**Subject:**  
**Page Index:** 2  
**Date:** 4/11/2024 9:30:56 AM  
**Author:** Jeff Rice - EPC Engineering Review  
**Color:**   
**Layer:**  
**Space:**  
**Page Label:** [4] 4 CUT & FILL MAP

**Subject:**  
**Page Index:** 4  
**Date:** 4/10/2024 3:56:04 PM  
**Author:** Jeff Rice - EPC Engineering Review  
**Color:**   
**Layer:**  
**Space:**  
**Page Label:** [9] 9 GRADING & EROSION CONTROL INTERIM PLAN

**Subject:** Callout  
**Page Index:** 7  
**Date:** 4/10/2024 4:04:32 PM  
**Author:** Jeff Rice - EPC Engineering Review  
**Color:** ■  
**Layer:**  
**Space:**  
**Page Label:** [12] 12 GRADING & EROSION CONTROL FINAL PLAN

**GRADING & EROSION
CONTROL INTERIM PLAN**

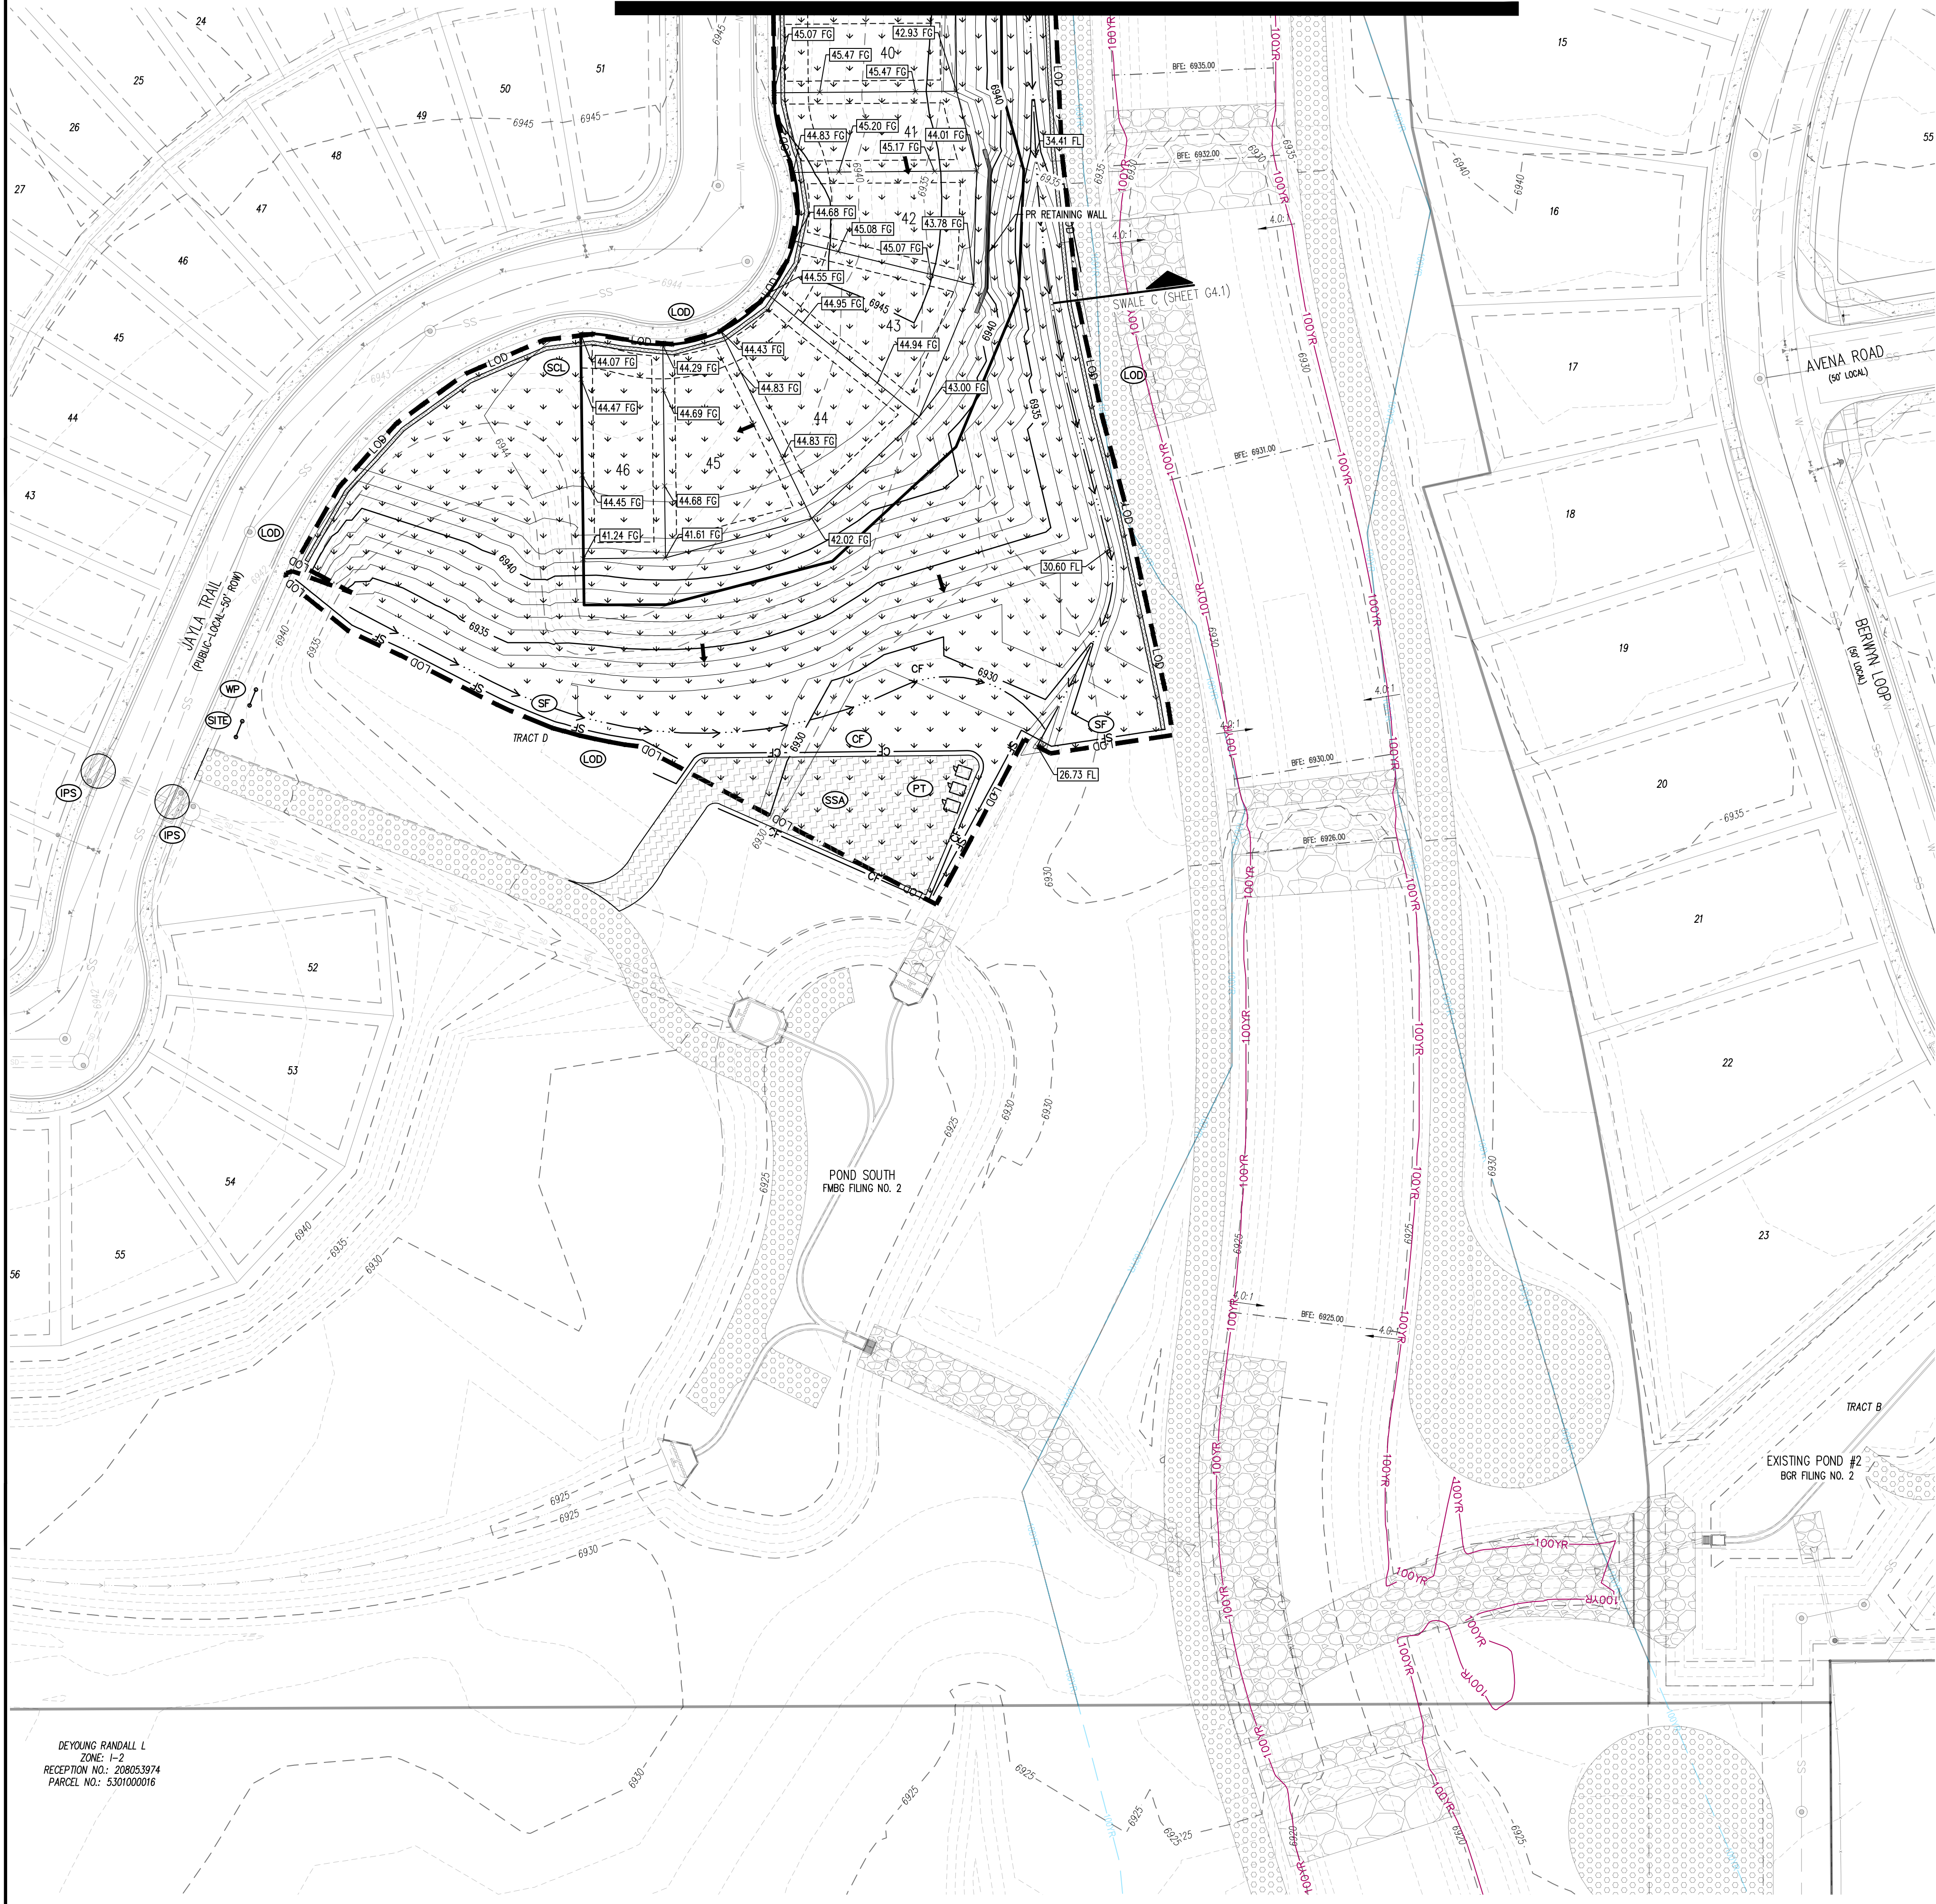
reference plans

Label effective width of access road, provide cross-section at narrowest width.
